Detached double garage & single storey extensions to existing garage.

Harcourt West Drive Angmering

Thank you for your internet representation made on 10th August 2017 which has been recorded as '**an objection**' with the comments as follows:

PROPOSED ELEVATIONS NEW DOUBLE GARAGE

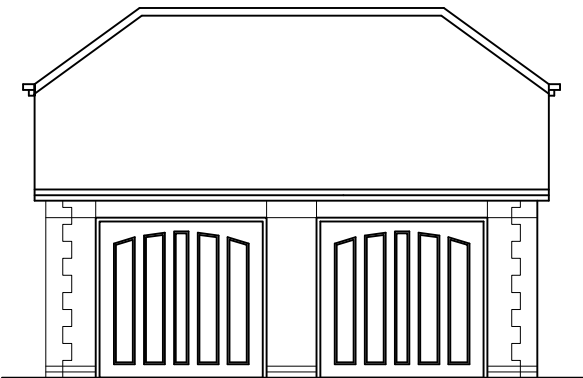
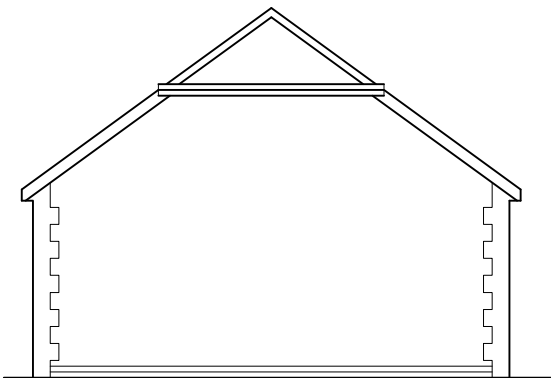
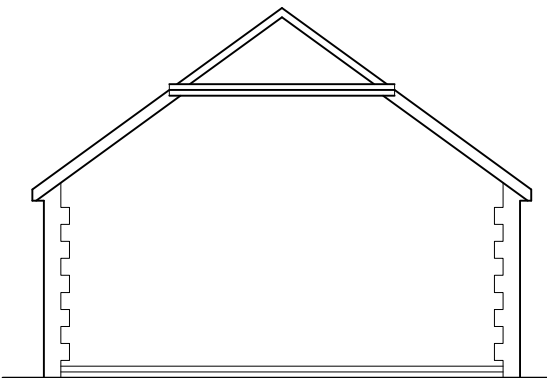
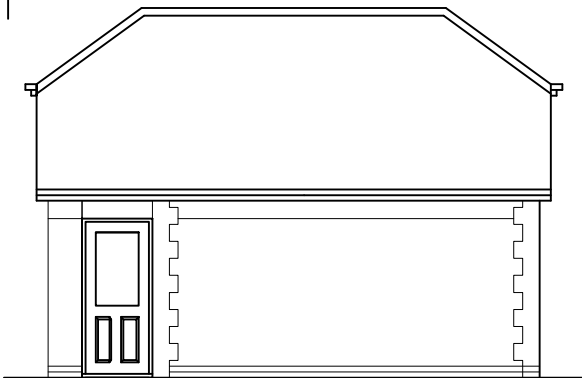
The proposed double garage parallel to West Drive will seriously impact on the street scene and considerably alter the character of this section of the road which is just before the entrance to the Golf Club. The proposed landscape when grown will create a high block adjacent to the road which is out of keeping with the entire area of the estate. The access onto the highway of west drive will be at a very dangerous angle and with the landscaping suggested being a blind area for the exit and more importantly for those exiting from the Golf Club who will have severely restricted vision of a vehicle exiting from the side road.
